2005-0139

Single Family Home 40'x 28'

RE: Application for Single Family House, Farragut Street, ID # 2005-0139

SKETCH PLAN
 84 FARRAGUT STREET PORTLAND, MAINE

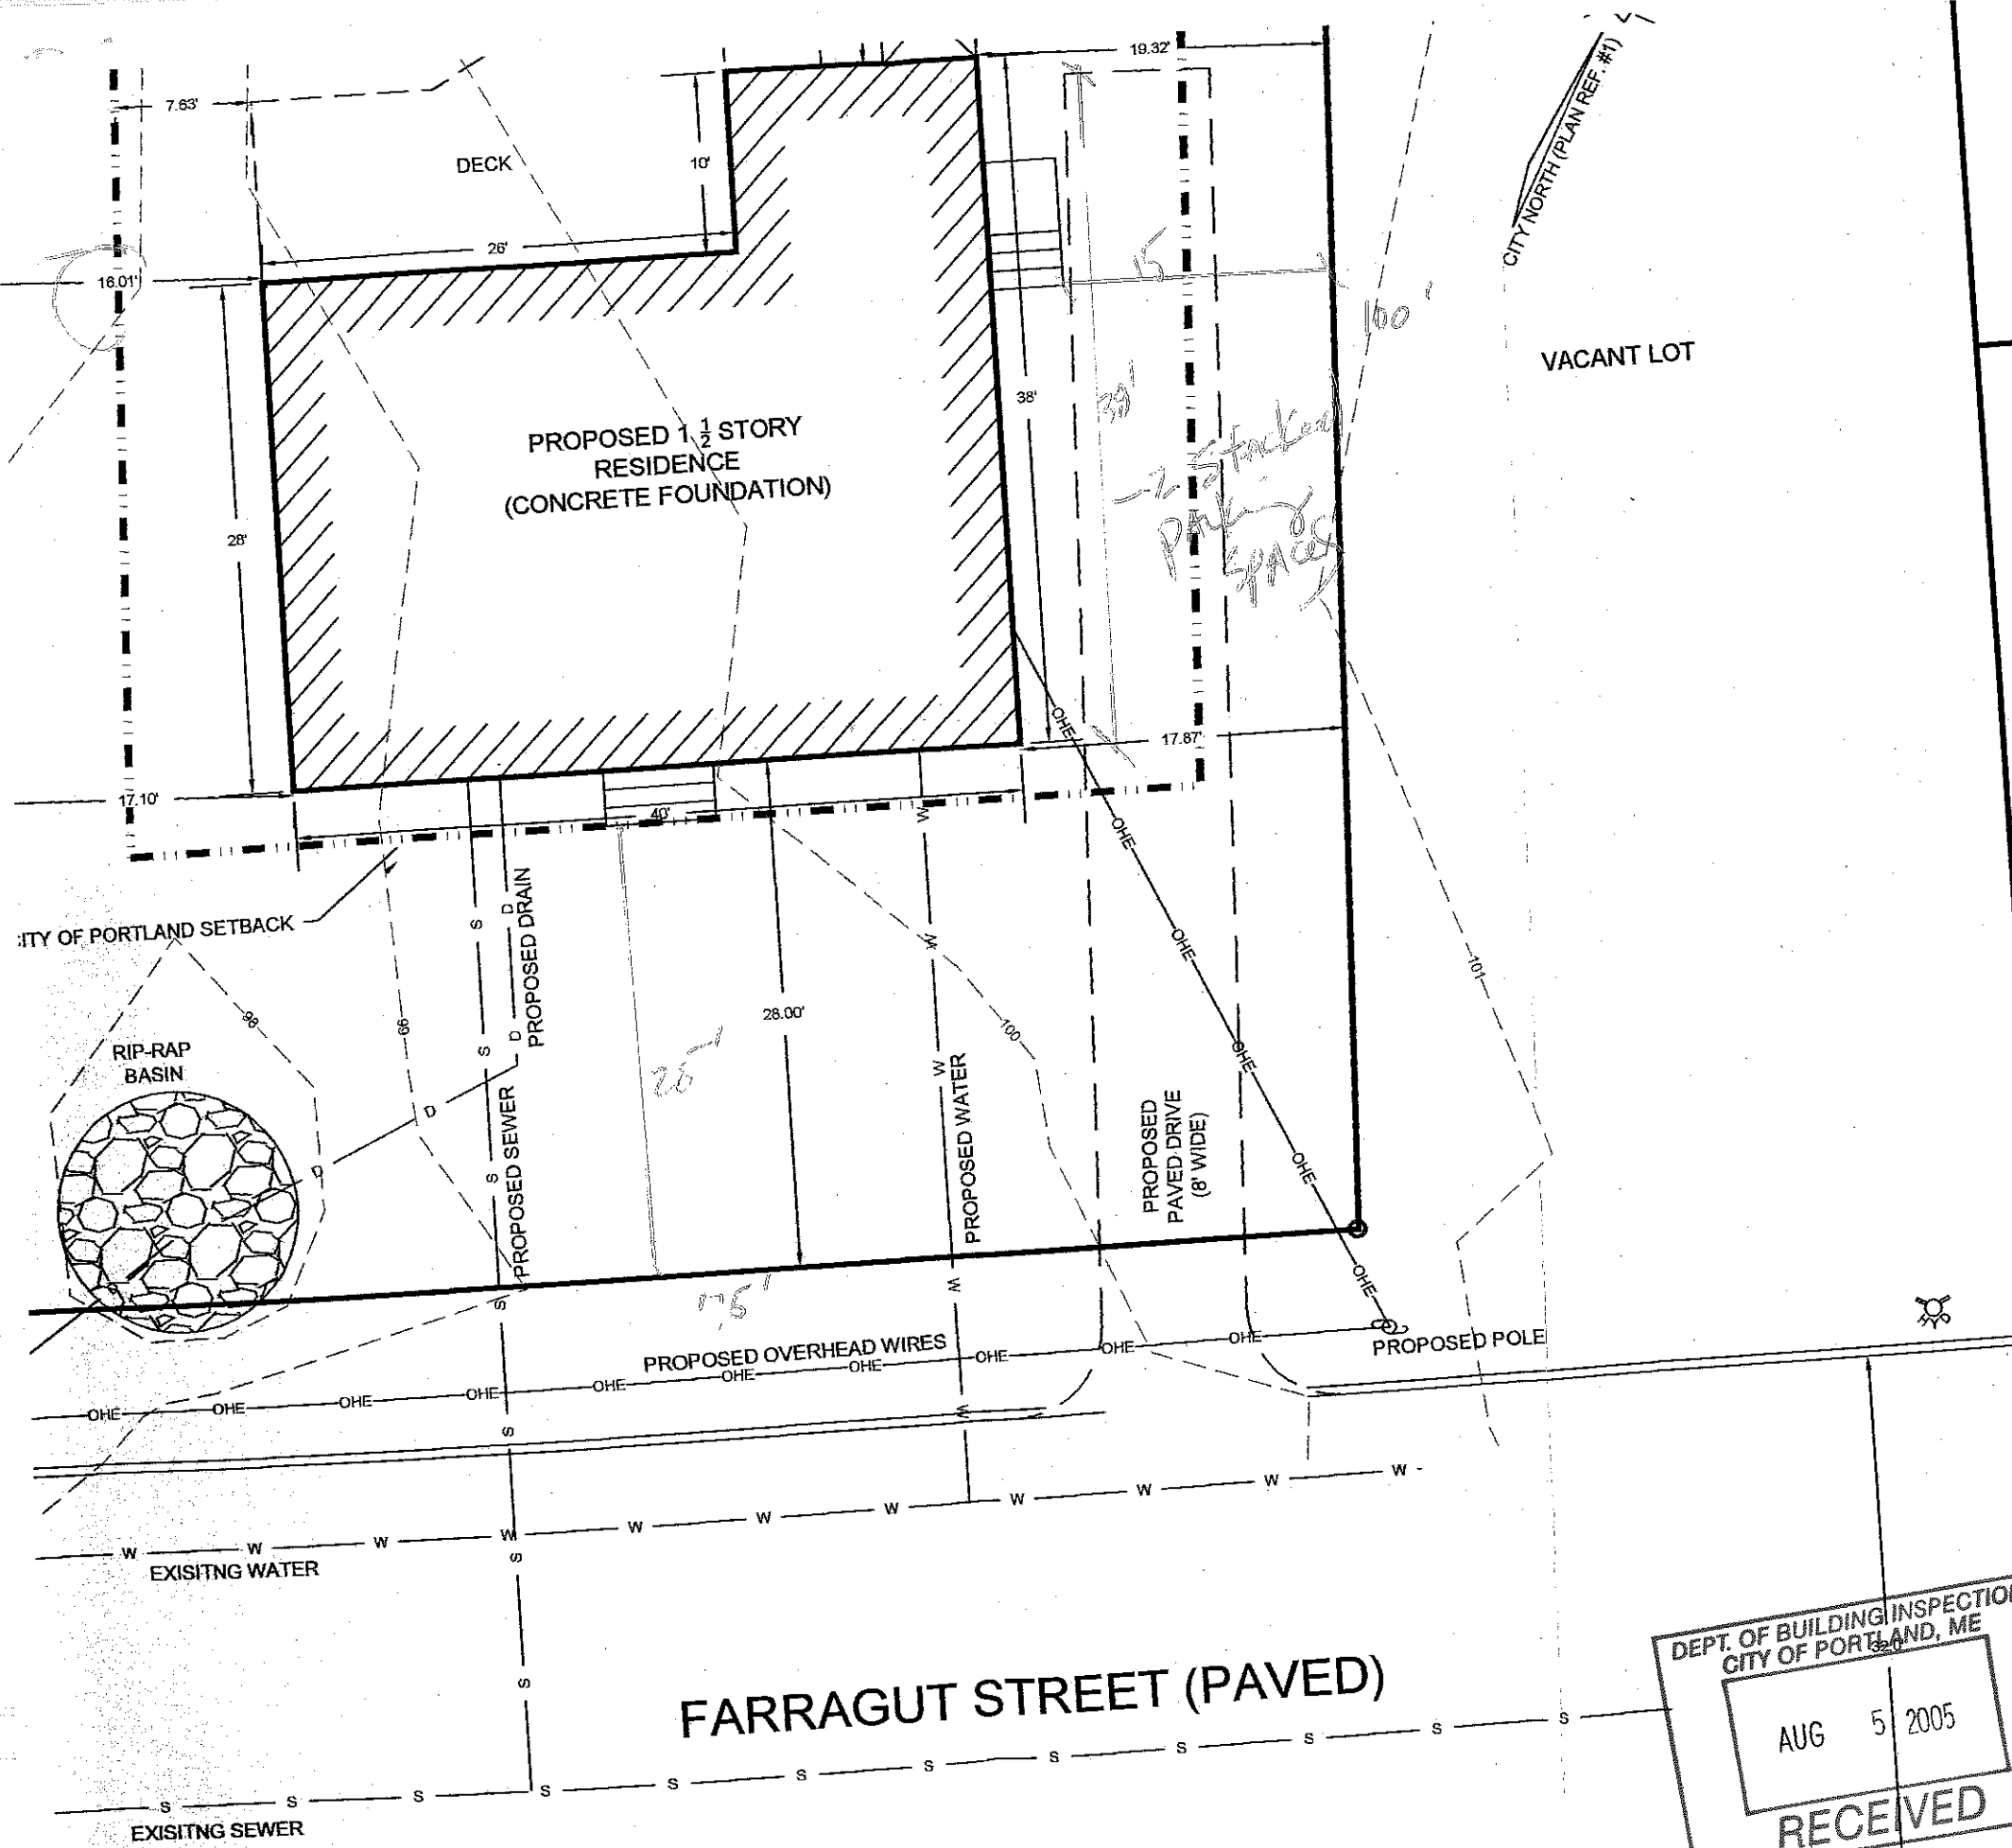
1. Please provide proposed grading/topography on the lot. This should match the previously approved grading as shown on the Farragut Street Extension plans approved on April 16, 2003. Add to plan.
2. Please note the Finish floor elevation. This should be tied into the same elevation data as your proposed topography.
3. Add the distances of the lot lines to the site plan.
4. Two street trees are required for single-family development, along your street frontage. Add to plan.
5. A backflow preventer is highly recommended on the 4" storm drain lead. Please add a note to the plan.

SKETCH PLAN
90-94 FARRAGUT STREET PORTLAND, MAINE

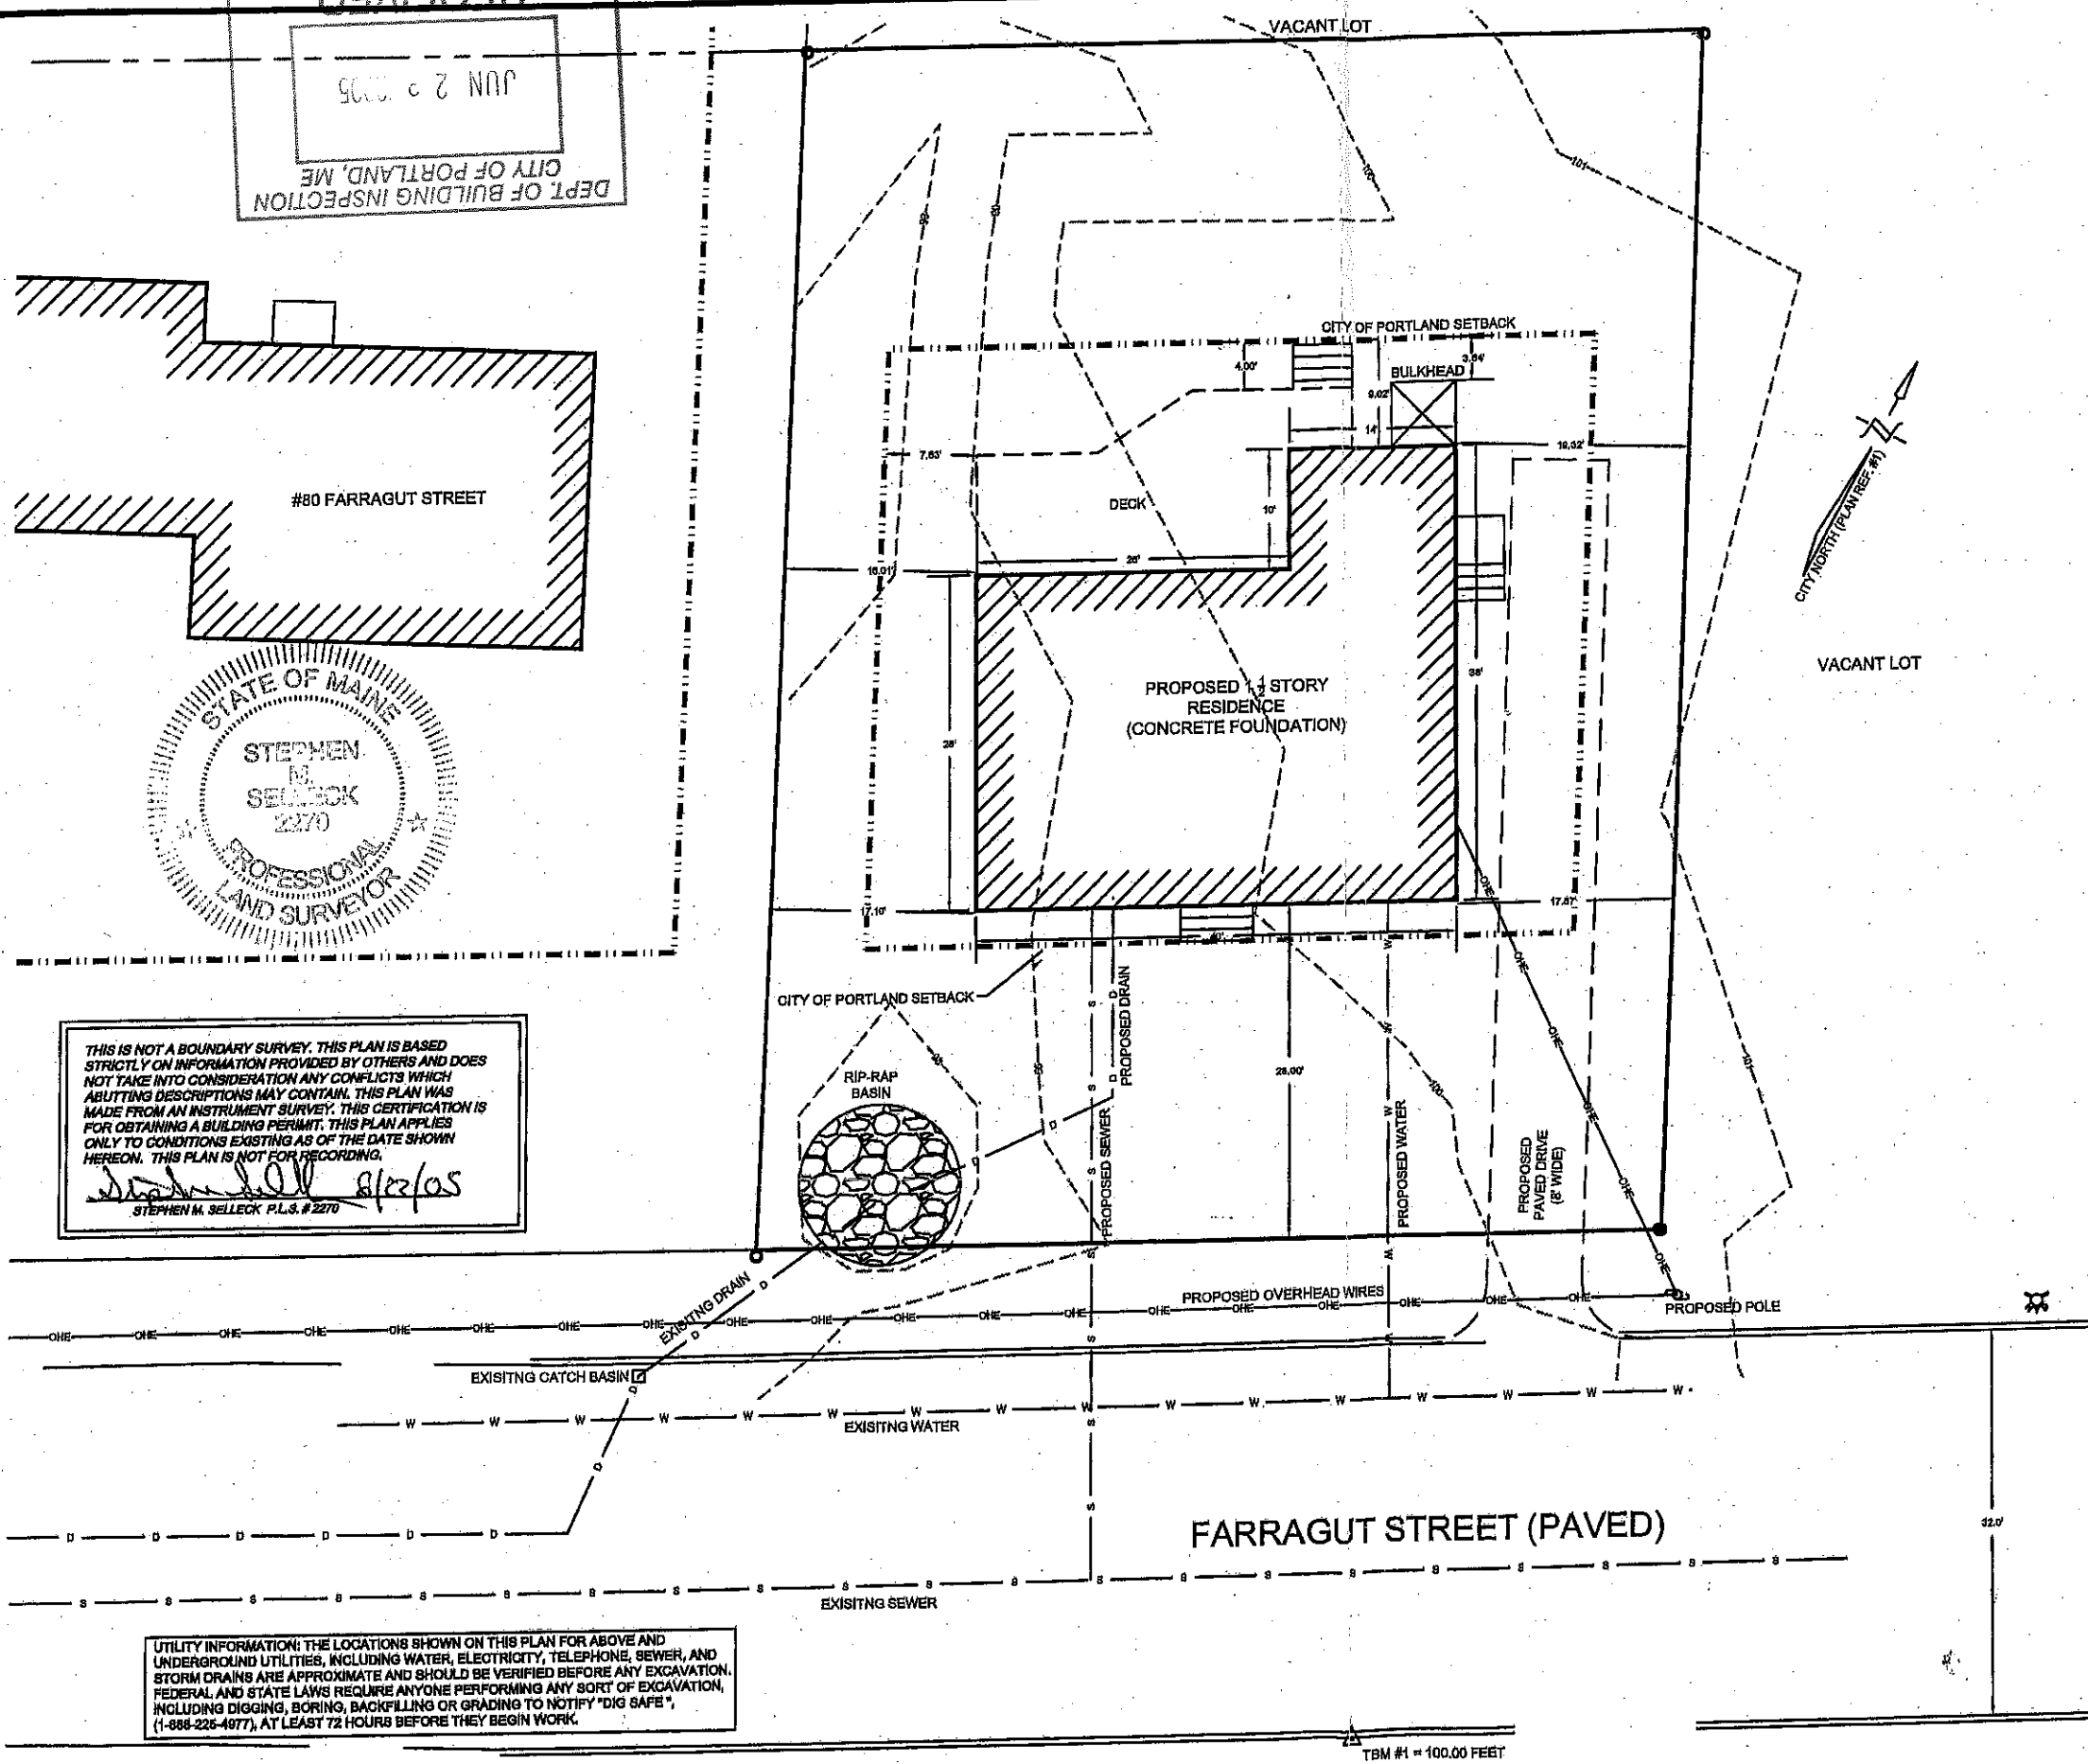
8-5
Revised Plans Do Not Address Any Comments
